From [REDACTED]
Sent: 15 July 2021 16:04
To: [REDACTED]
Cc: ENC PLANNING <PLANNING.ENC@northnorthants.gov.uk>
Subject: FW: Planning Application NE/21/01069/FUL

REF NE/21/01069/FUL Single storey ancillary accommodation to replace existing single garage at Pond Yard 32, Back Lane, Collyweston, Northamptonshire, PE9 3PJ

Date	Scale	Drawn
15/07/2021	1:100@A1	JJF
Job No.	Drawing No.	Revision
21-956	(08)003	B

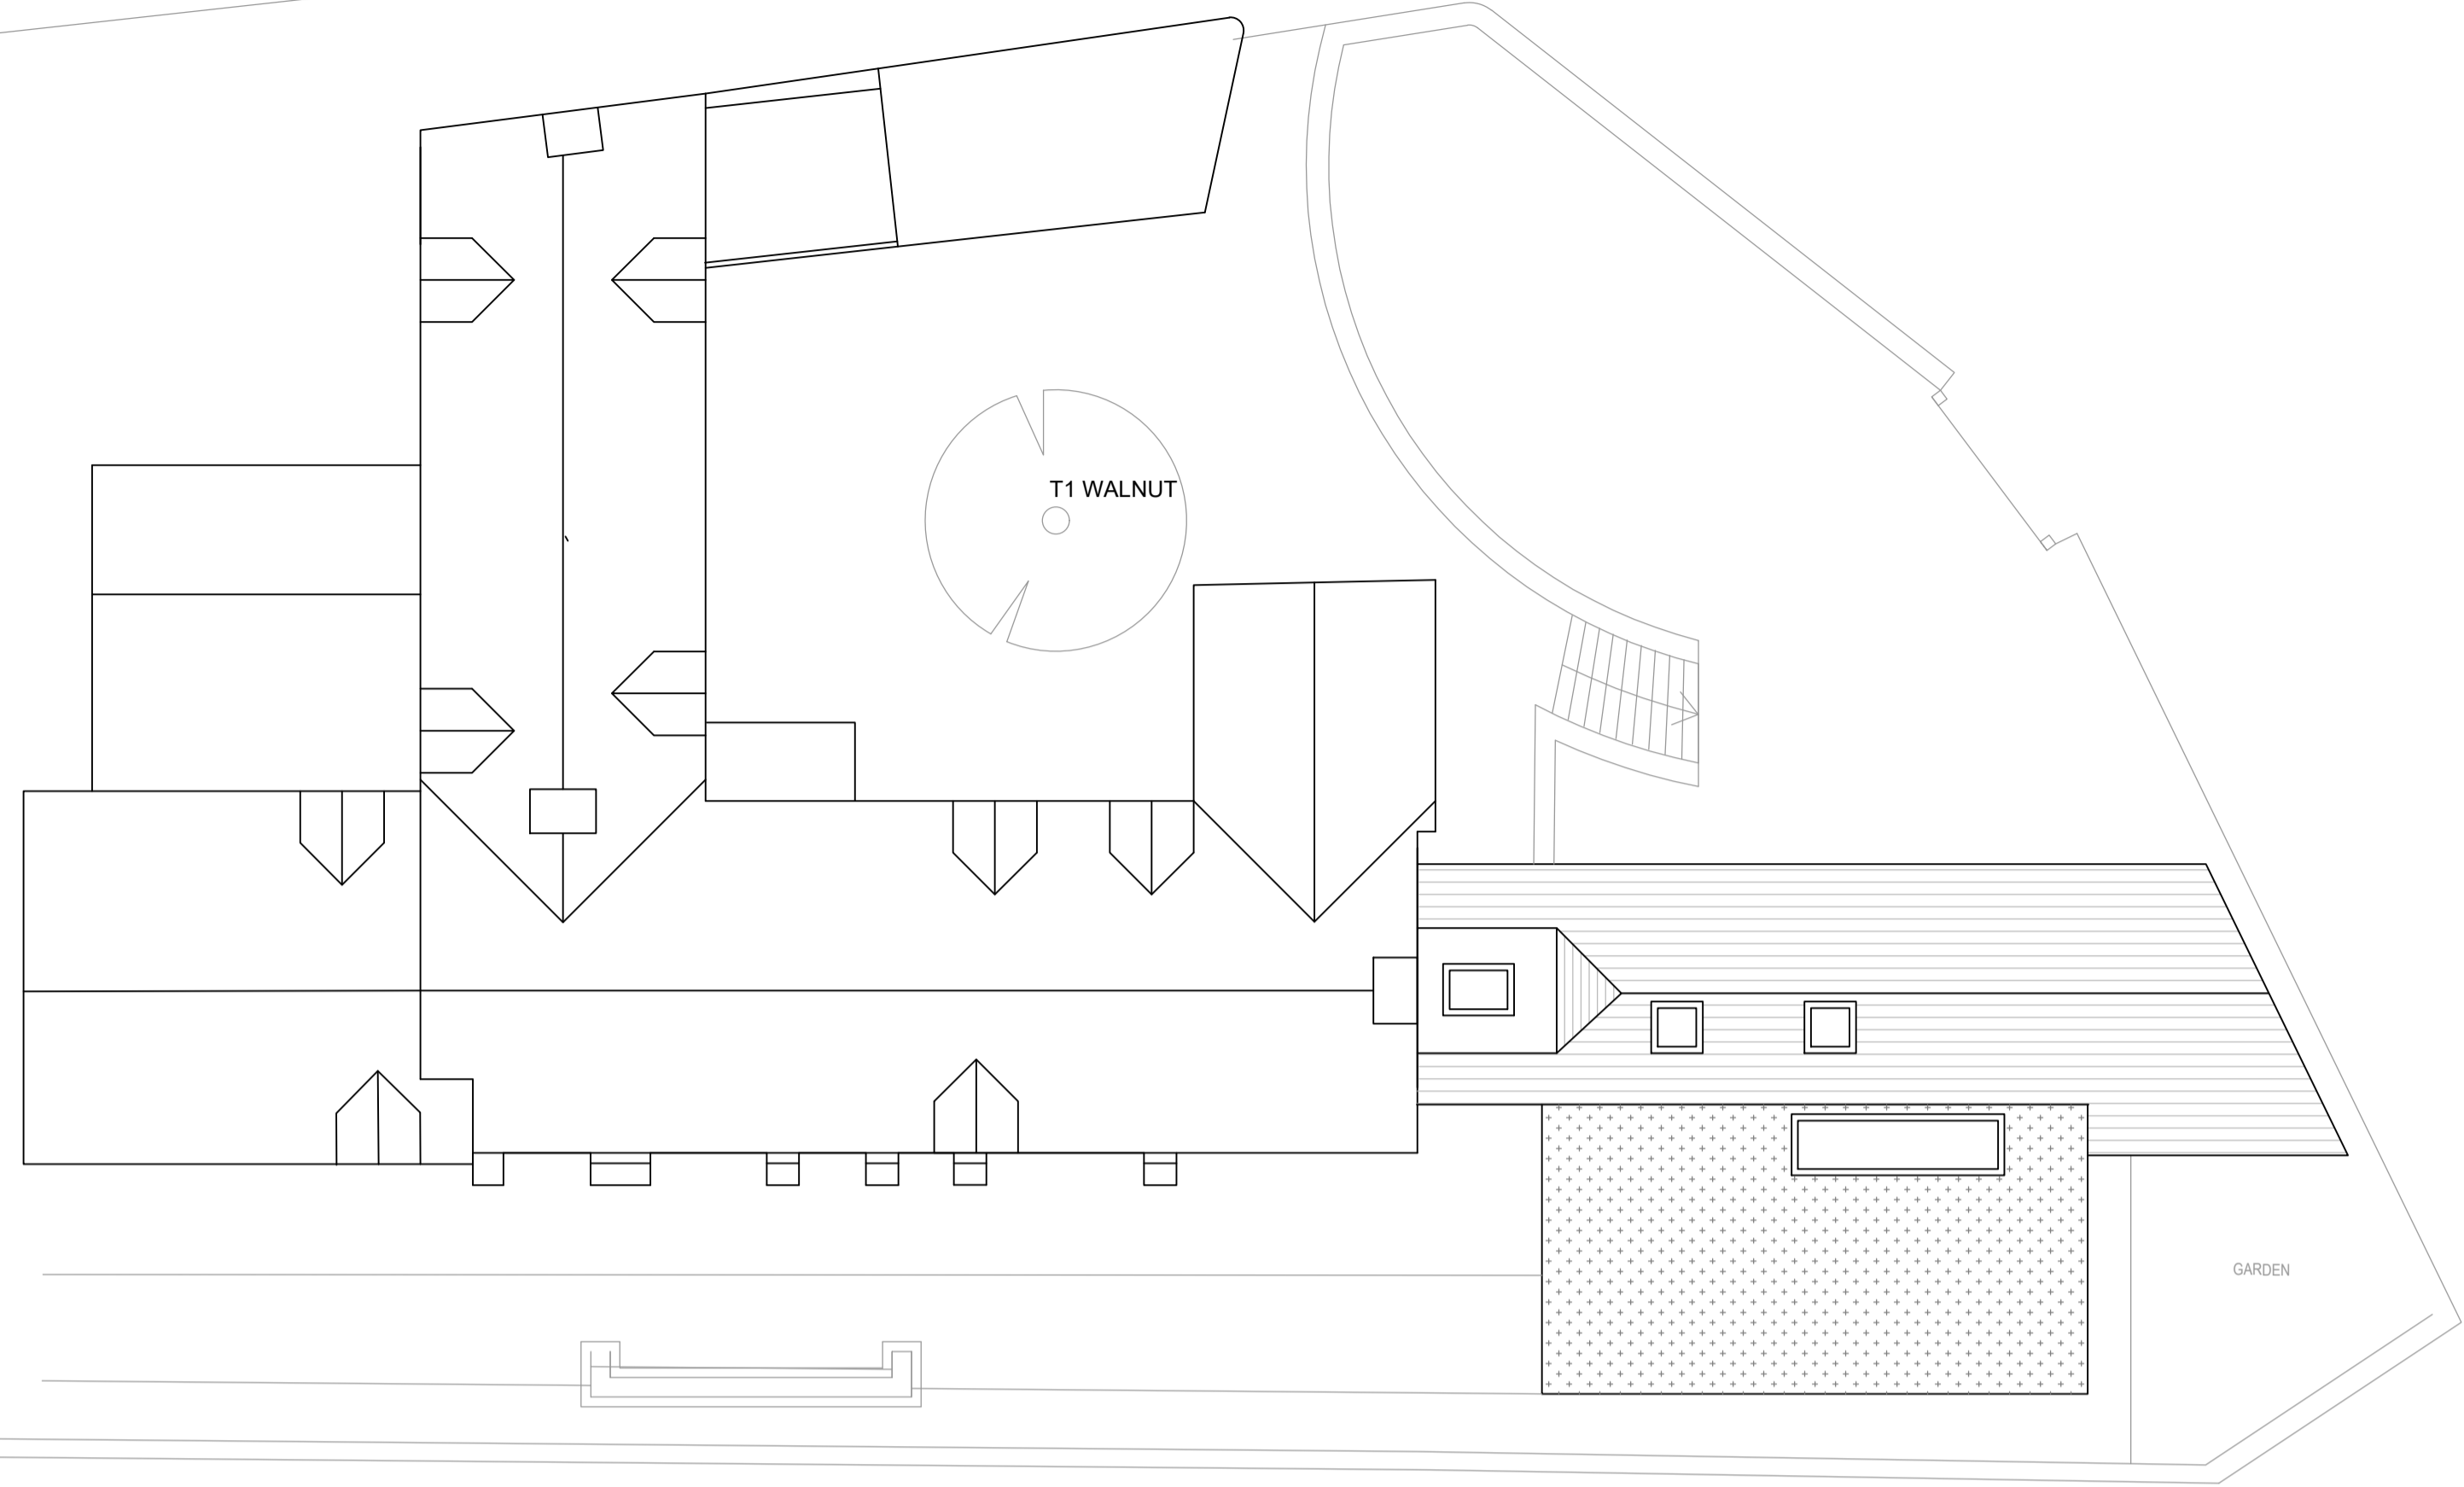
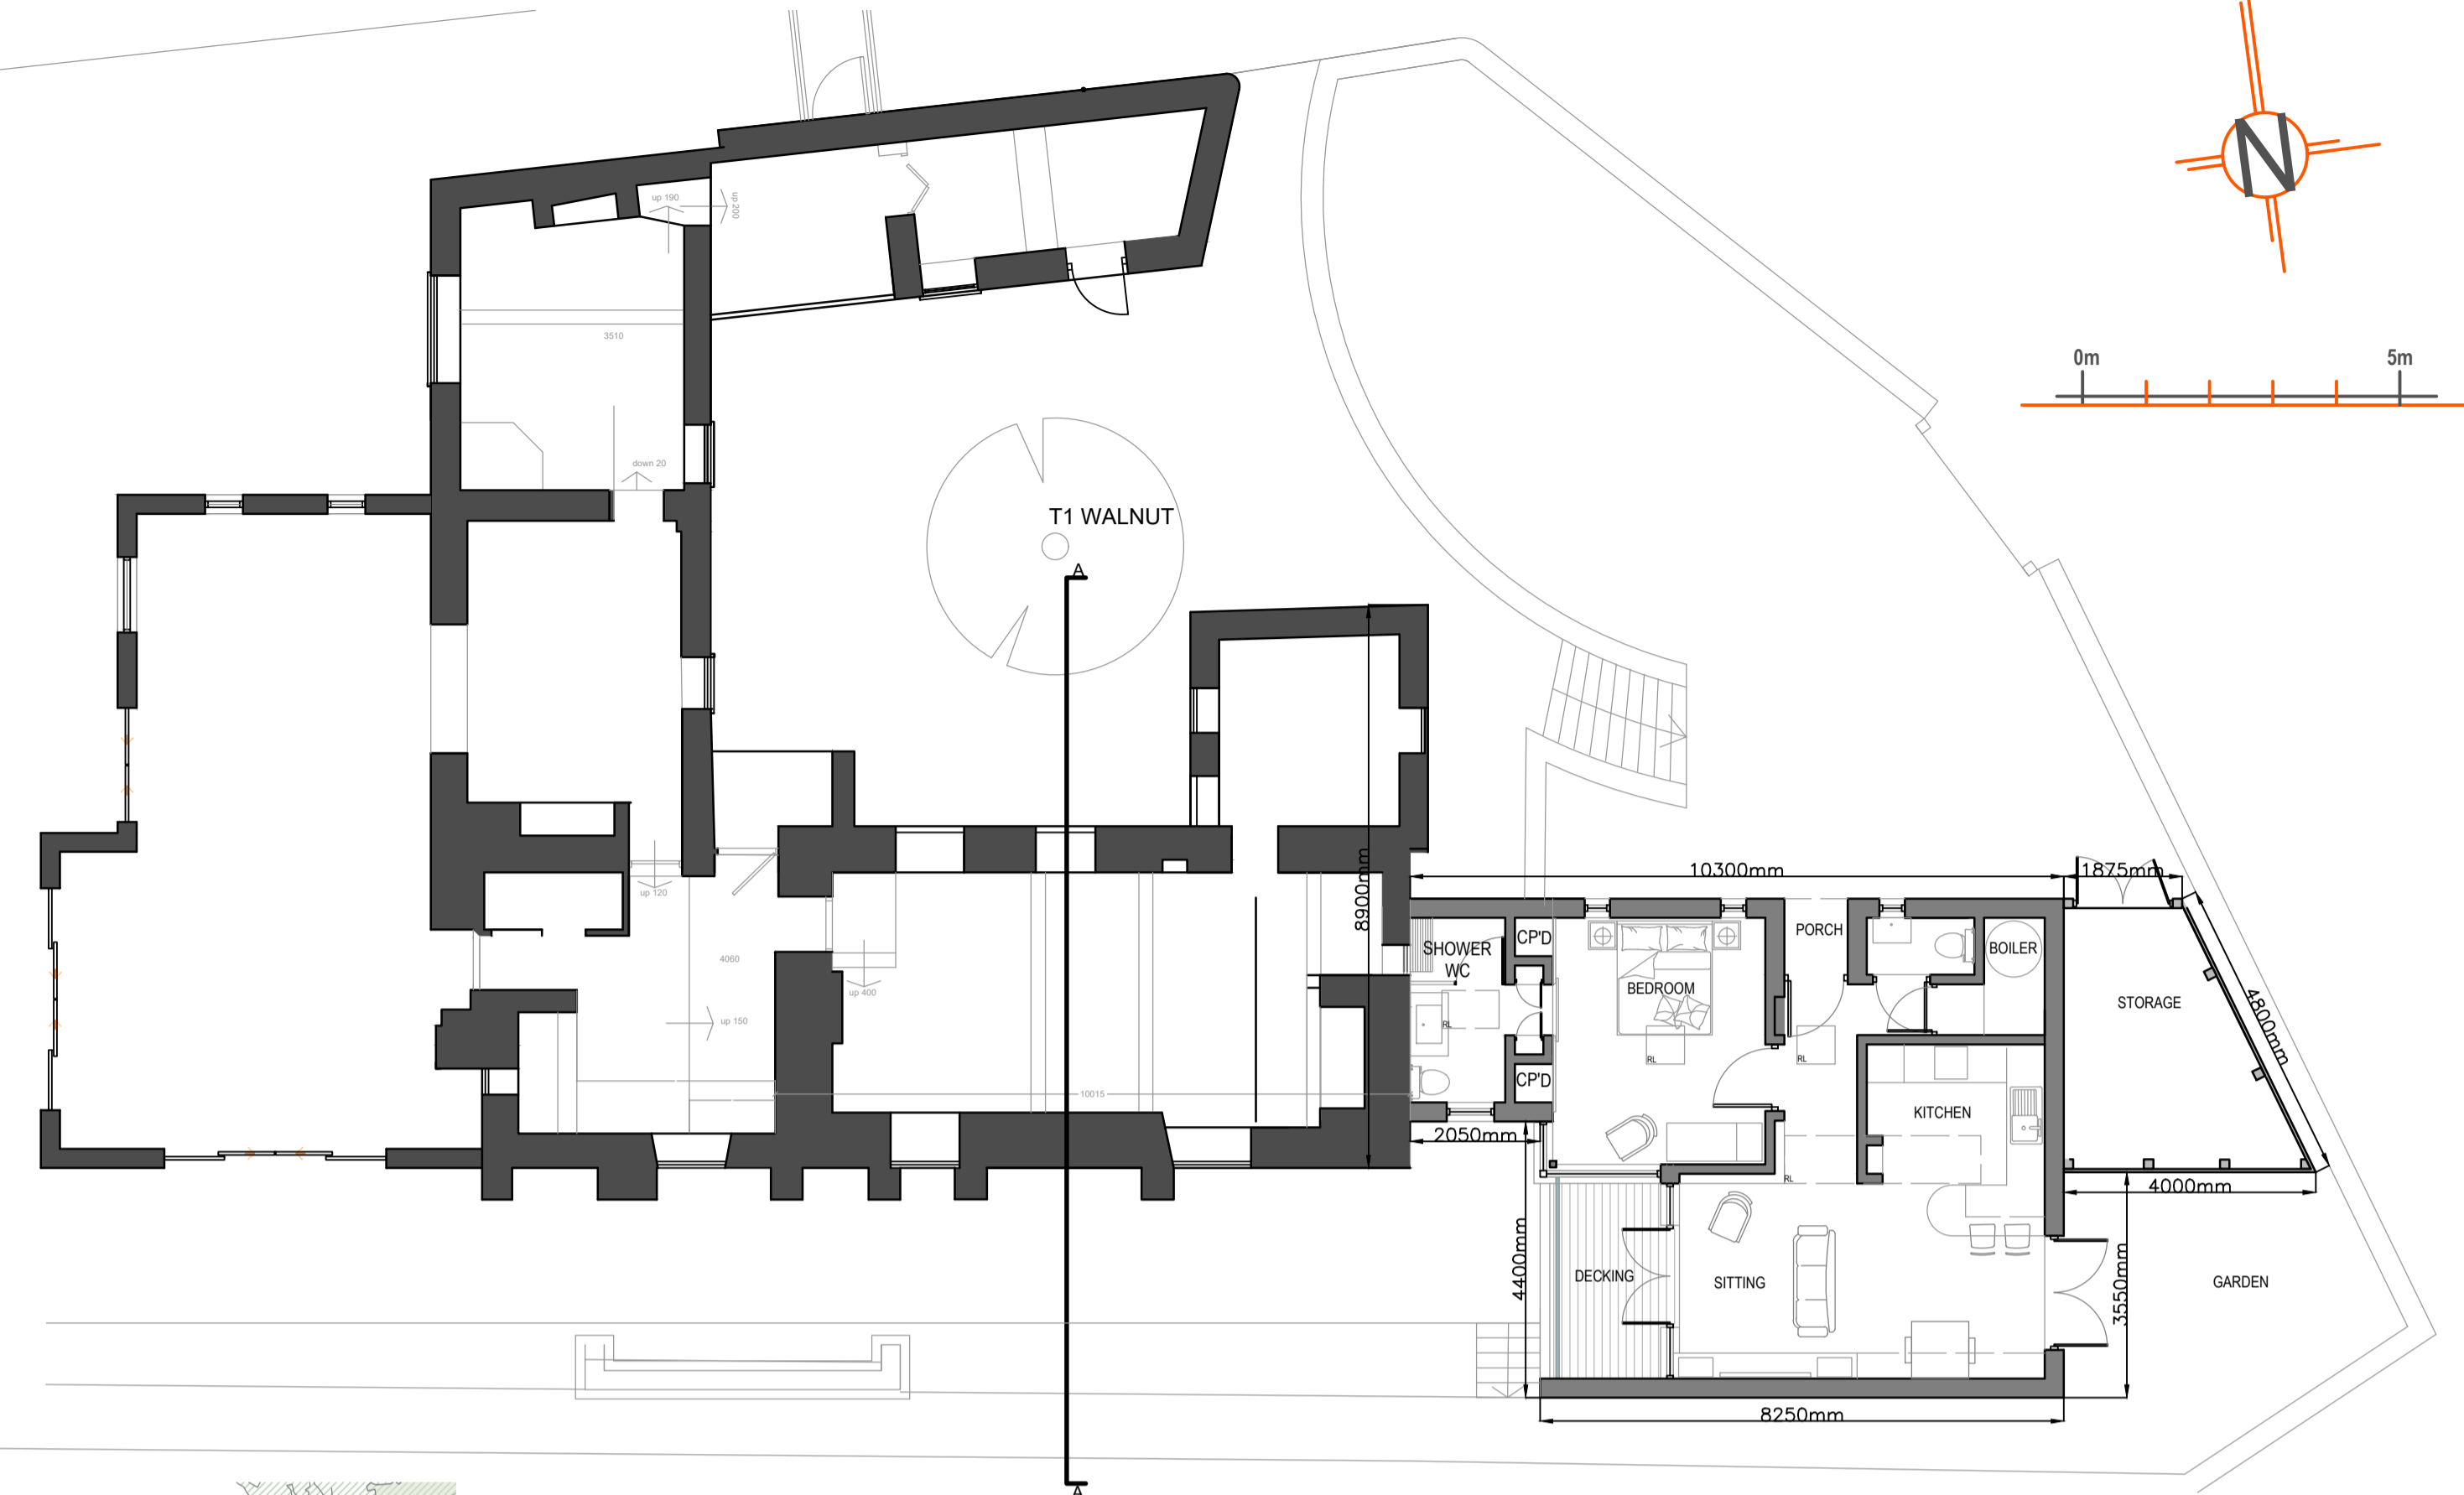
Thank you for the drawings received today, I have accepted the existing floor plans and elevations for validation, I note however that the dimension shown next to the decking on the proposed floor plan as measuring 8900 mm may be incorrect as when measured it comes to just under 4500 mm, this will need to be corrected
